56 Ballpark Dr. Lot#6
Project Name/Description

RE: Application for single family house, 56 Ball Park Drive, Lot #6

Upon review of the site plan, the City's Planning Division has the following comments:

**SITE PLAN**  
 Lot 6 - 3906 Balsapark Drive  
 PORTLAND, MAINE

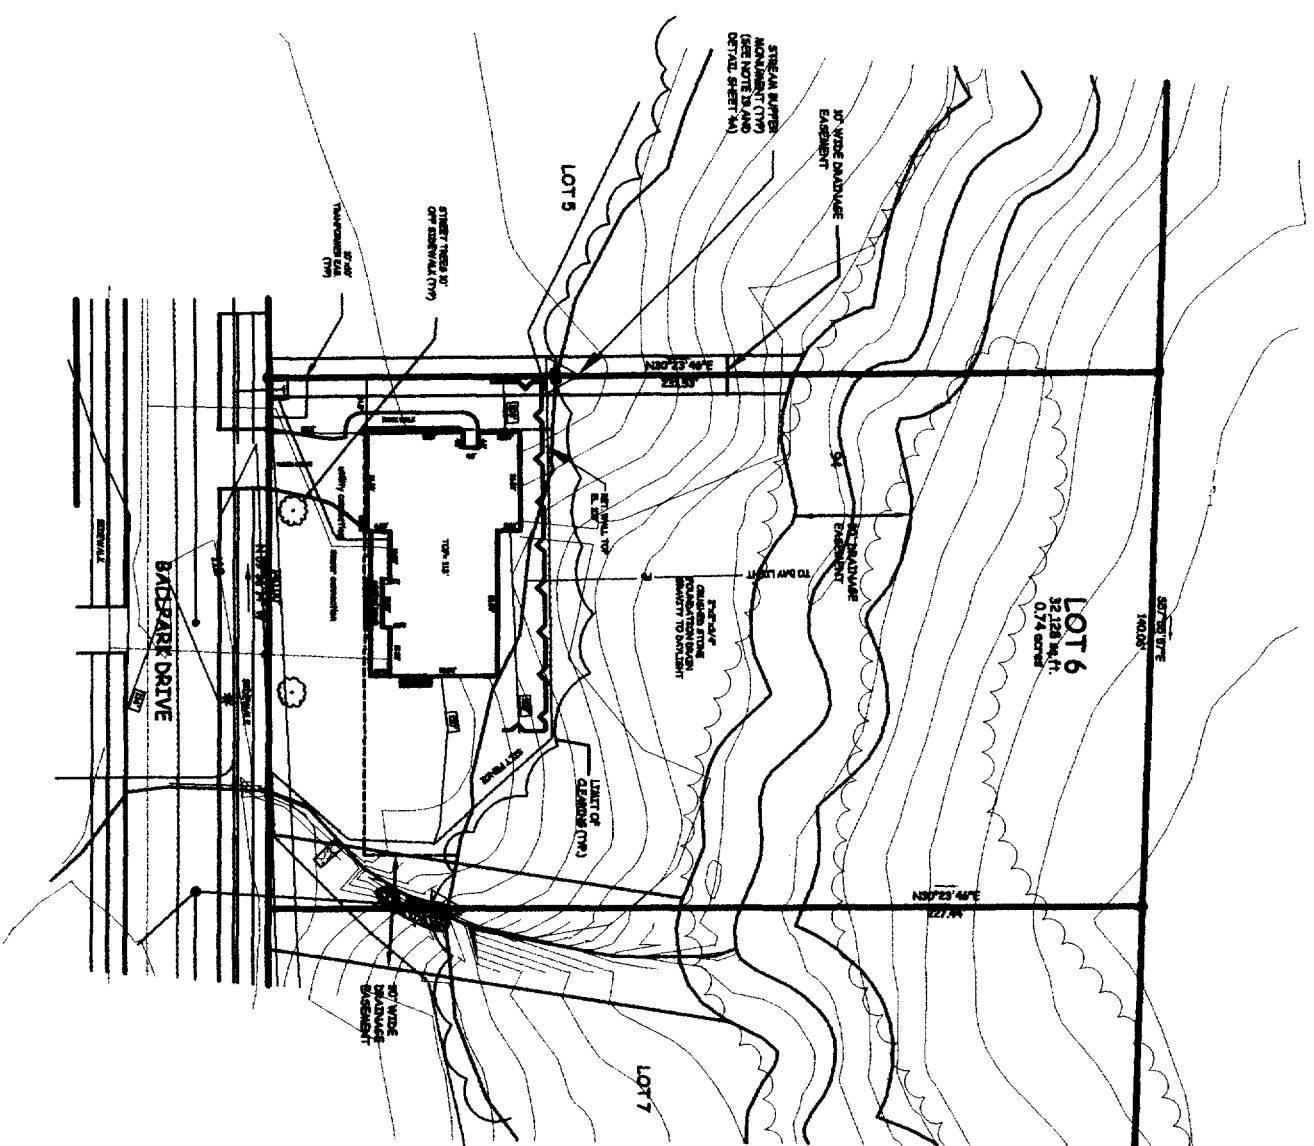
1. Please take note that there is a 75' stream protection zone in the rear of the property and that your proposed retaining wall is only 3 feet from it. It will be important to limit your construction area along the wall so that you remain in compliance.
2. Please redesign the outlet of the foundation drain so that it does not affect the stream protection zone. Based on your proposed foundation height, it looks like the discharge of the foundation drain can be located near the 103' contour. This can be achieved outside of the stream protection zone.
3. Where a new structure/retaining wall exceeds 4-feet in vertical drop, a guard rail is required for safety purposes. Please add this to your plan, as your wall appears to have areas where it exceeds 4-feet of vertical drop.
4. If possible, please provide a greater scale (1"=40', 1"=30, etc.) site plan.
